# DRB CASE ACTION LOG (PREL & FINAL)

| DRB Application No.: 06DRB-00051 (P&F) | Project # 1004638   |
| Project Name: PARADISE VALLEY SUBD.    |                     |

**DEVELOPMENT REVIEW BOARD**  
**TRANSPORTATION DEVELOPMENT**  
**Standard Comment Sheet**

1 Architectural Site Plan
 Scale: 1"=30'-0"

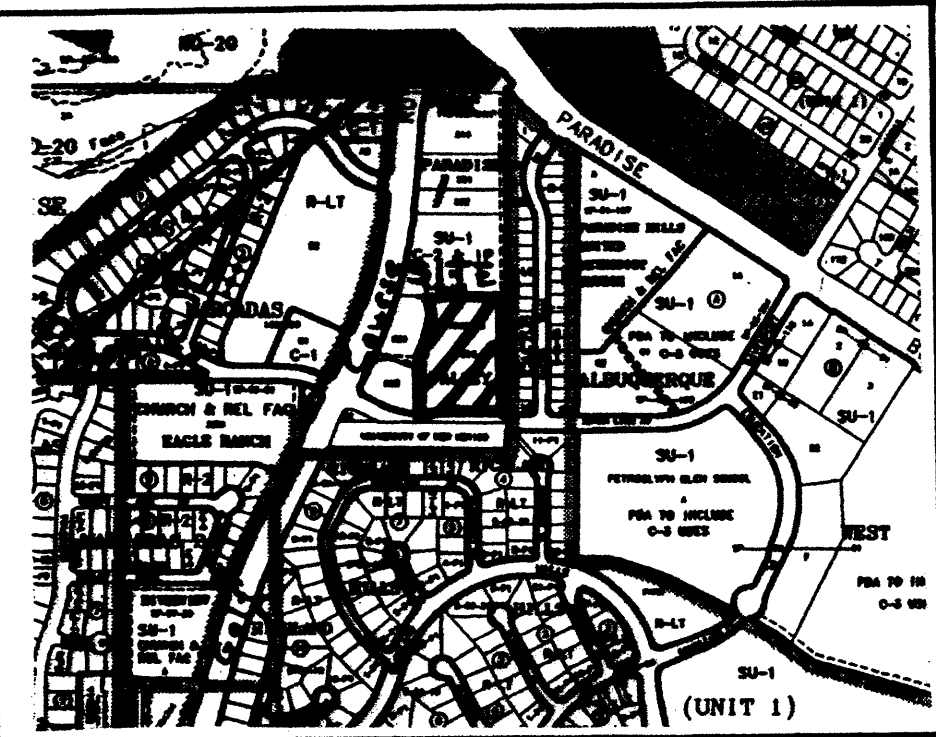
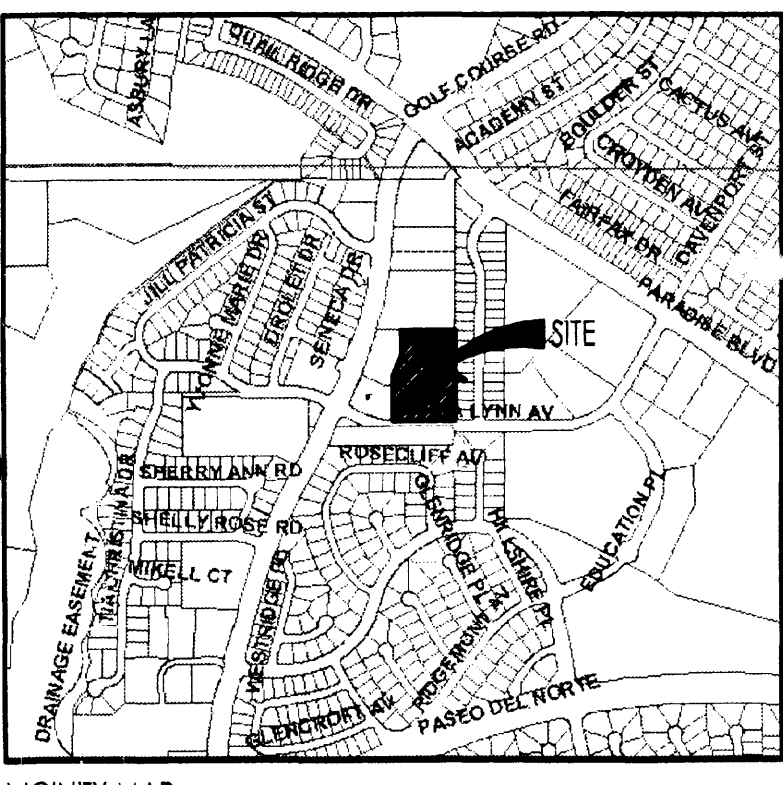
The Site Development plan must be amended through the Environmental Planning Commission process.

PLAT OF TRACTS 5-D3-A AND 5-D3-B PARADISE VALLEY

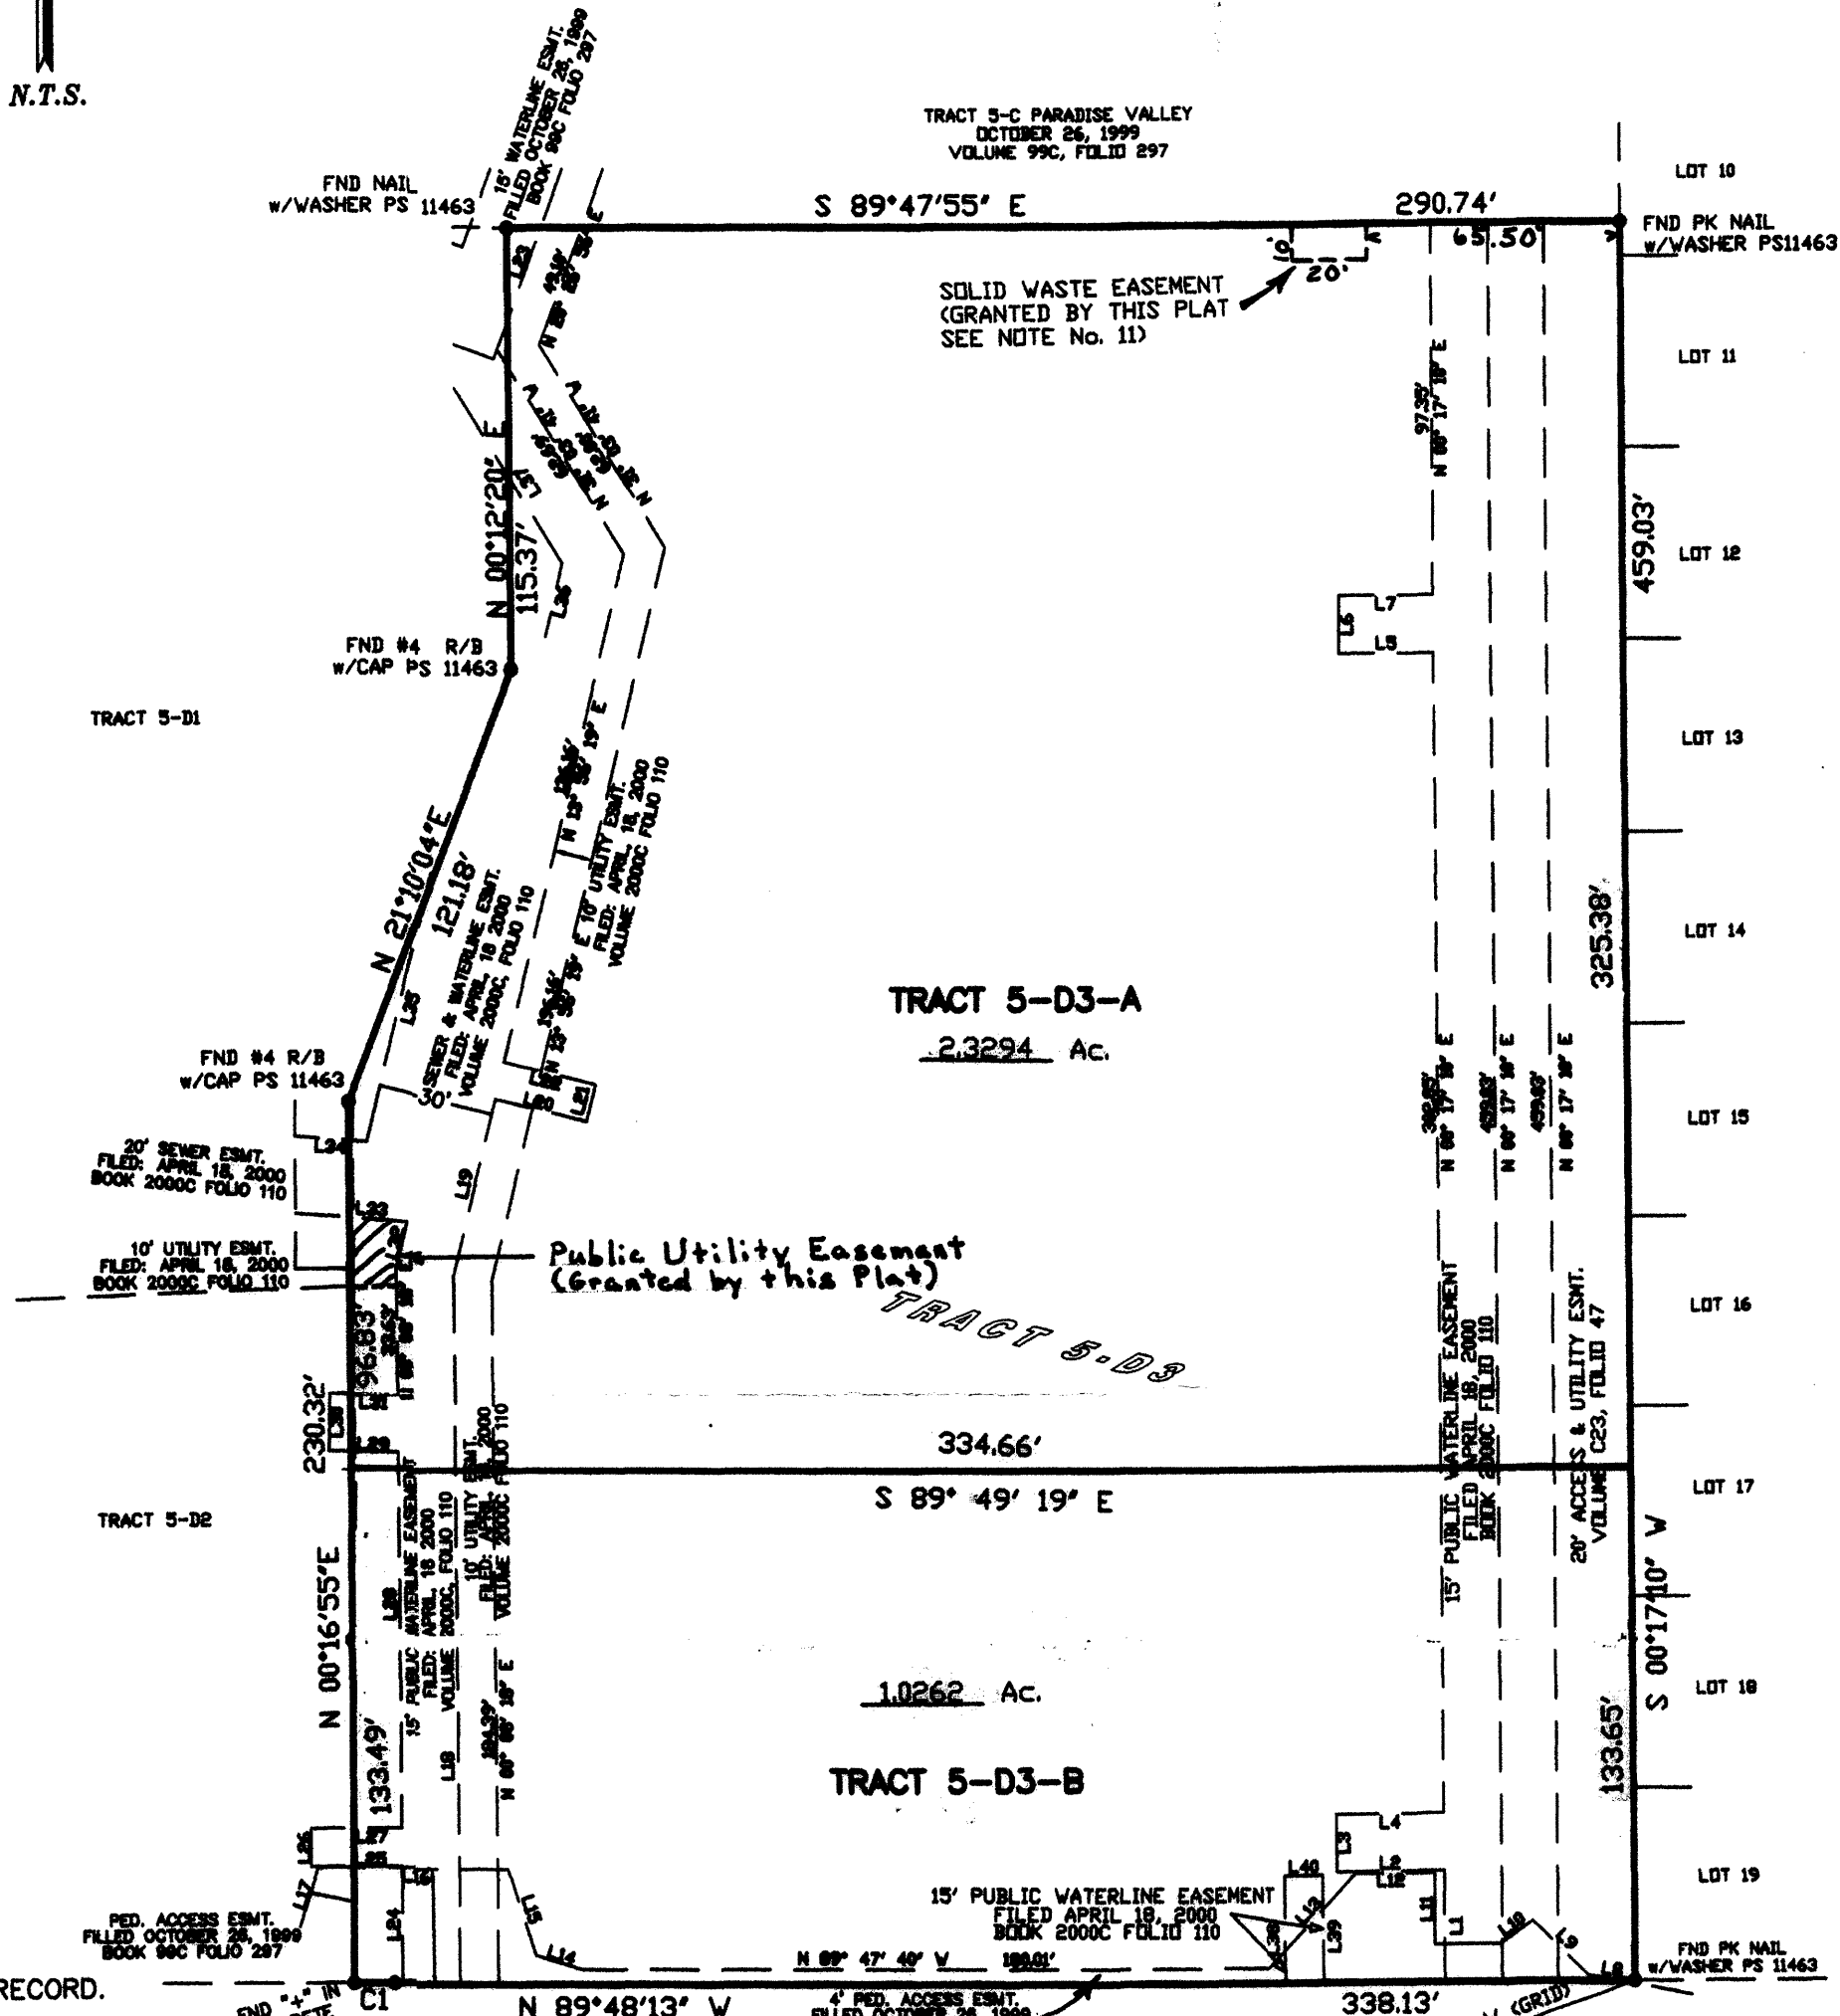
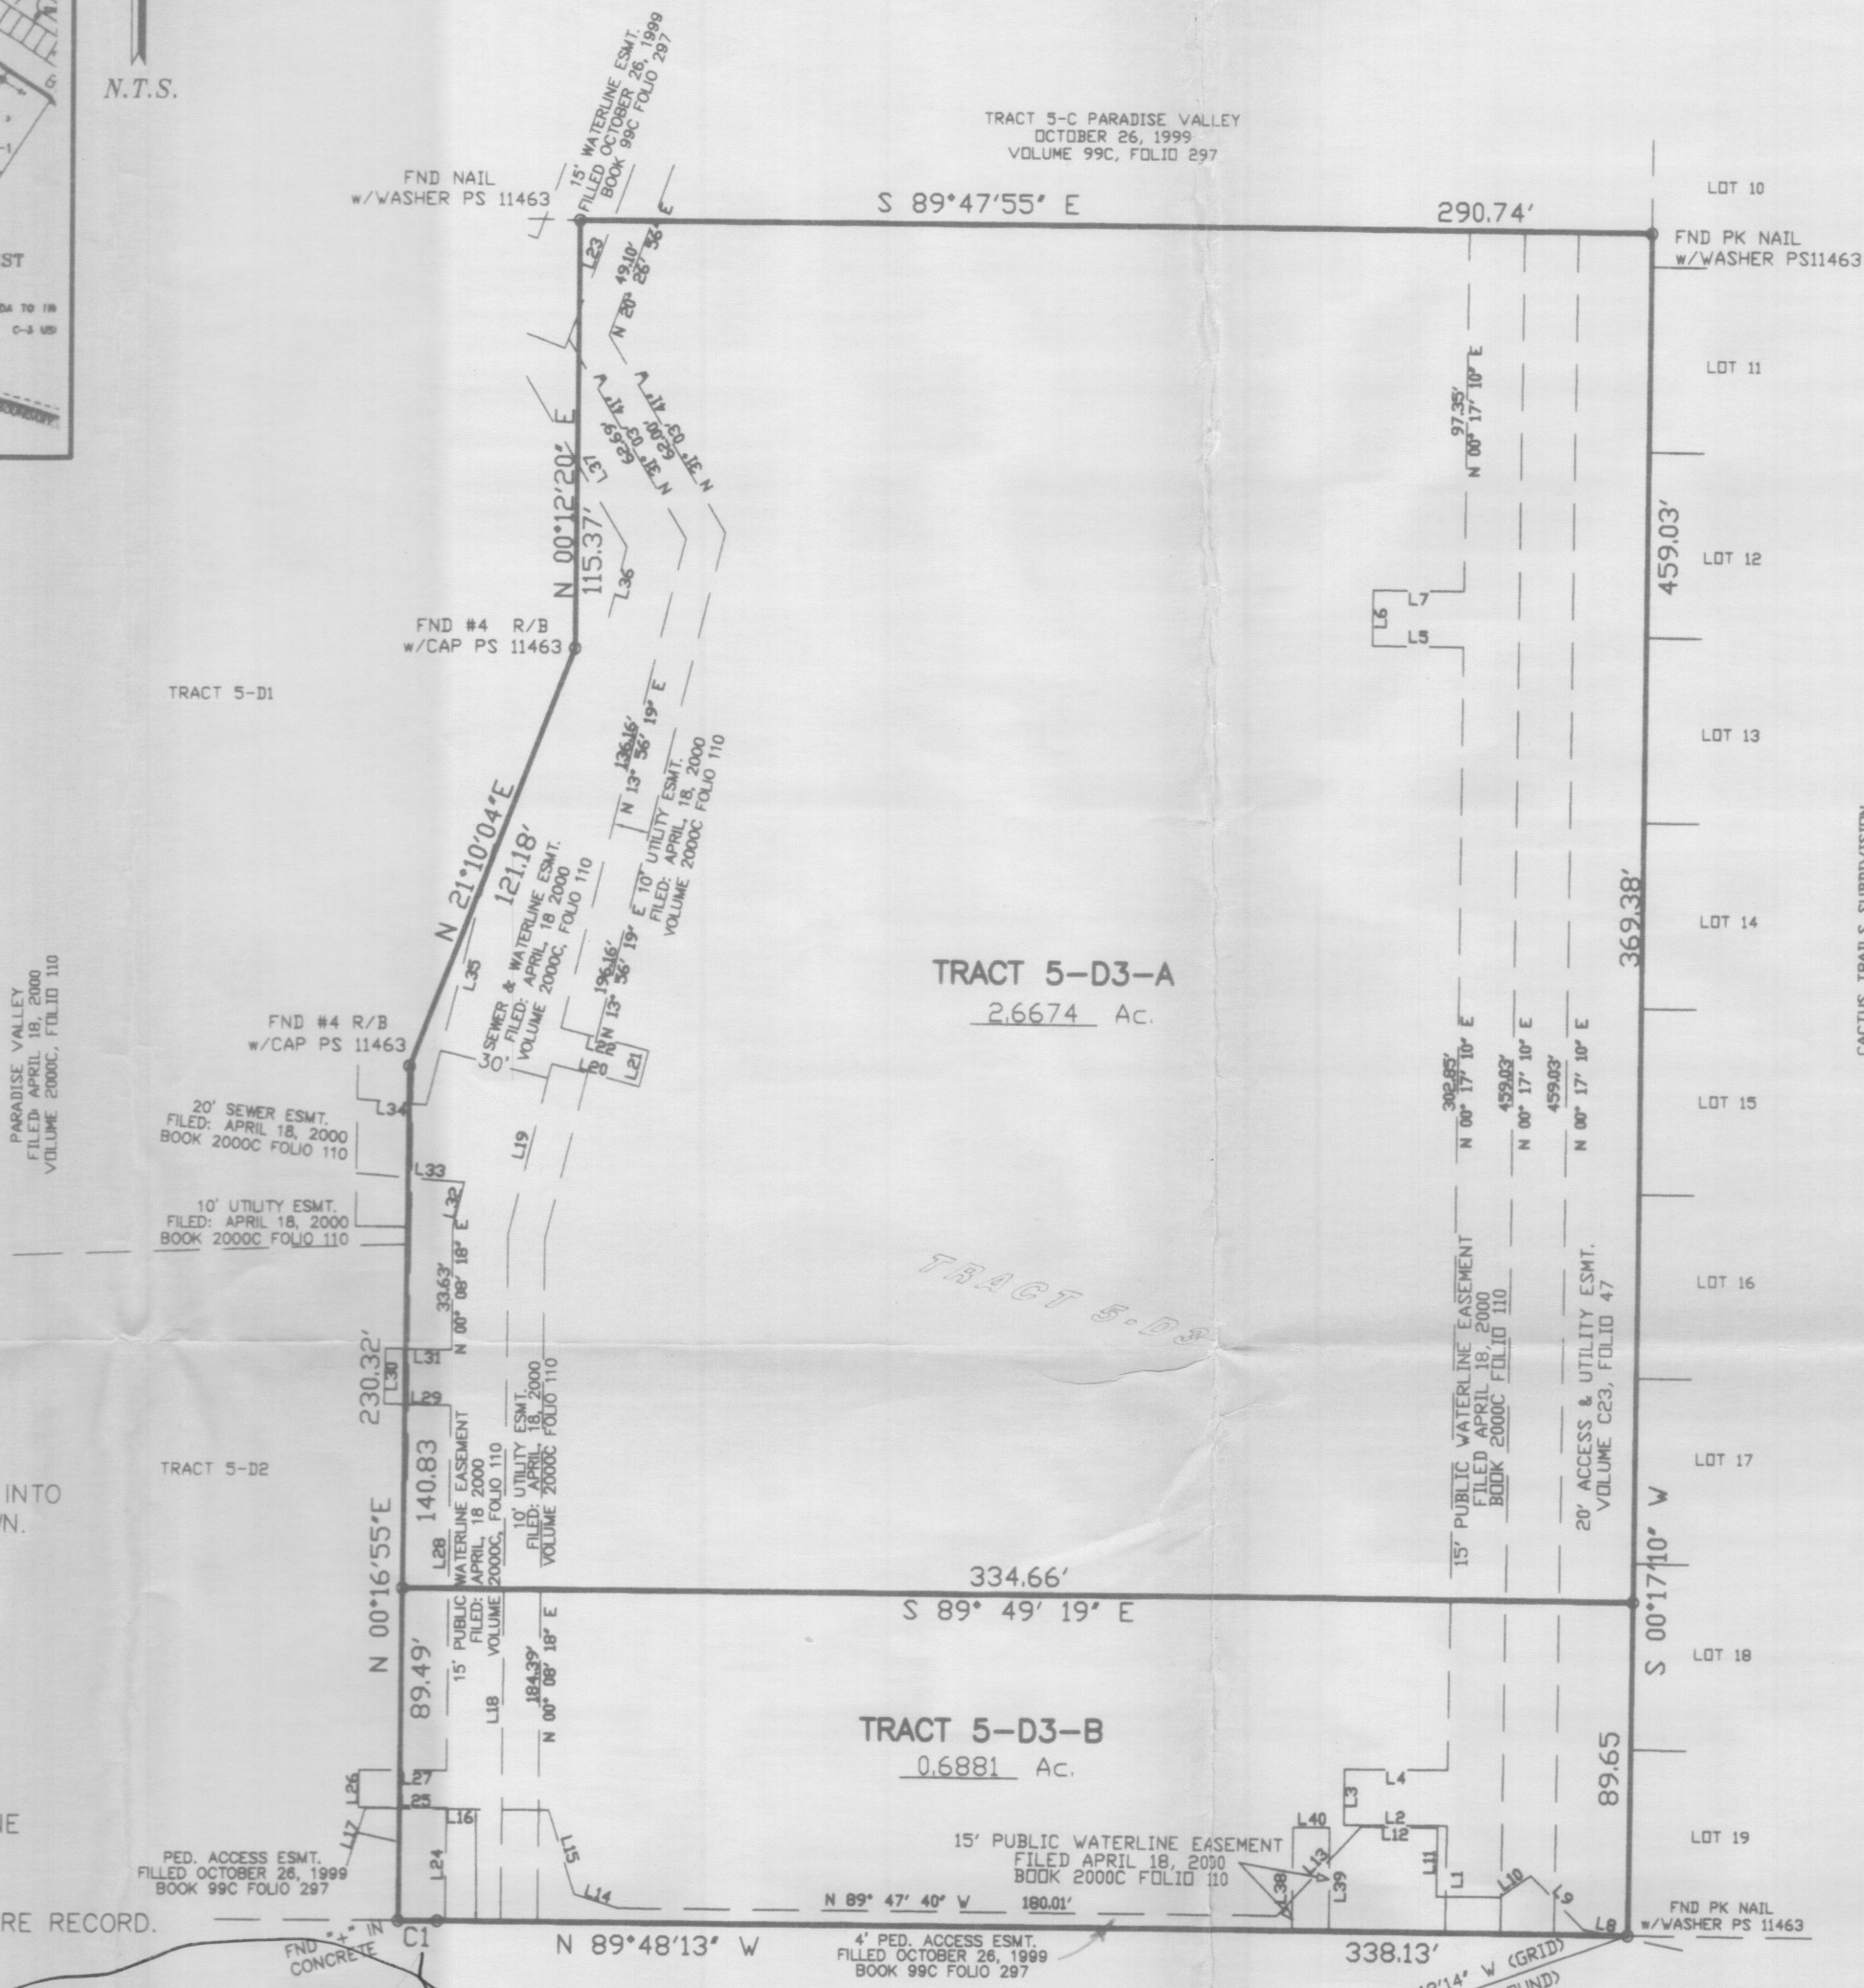
TRANSPORTATION: Sidewalk easement / okay  
 + NOTE: NO (MANT & DOWNT. ?)  
 \* DUMPSTER REQUIREMENT ?

PLANNING (Last to sign): Zoning change on the Plat.  
 Administrative Amendment Approval - Site plan - 7 lots  
 AGIS dxf  
 NM Utilities Signature. [Signature] 9/19/06

- 1) Why isn't the sidewalk along Marna Lynn within a sidewalk easement? Are the ADA ramps within a pedestrian easement?
- 2) The 20' access easement serves no purpose and is insufficient for access to the created tract. Where are the maintenance and beneficiaries of the easements?
- 3) Applicant will need to show that the parking is contained within the created lot.
- 4) Is a site plan for subdivision needed?
- 5) Where is the easement for the dumpster?

Maintenance and beneficiaries of the reciprocal easement must be stated on plat.
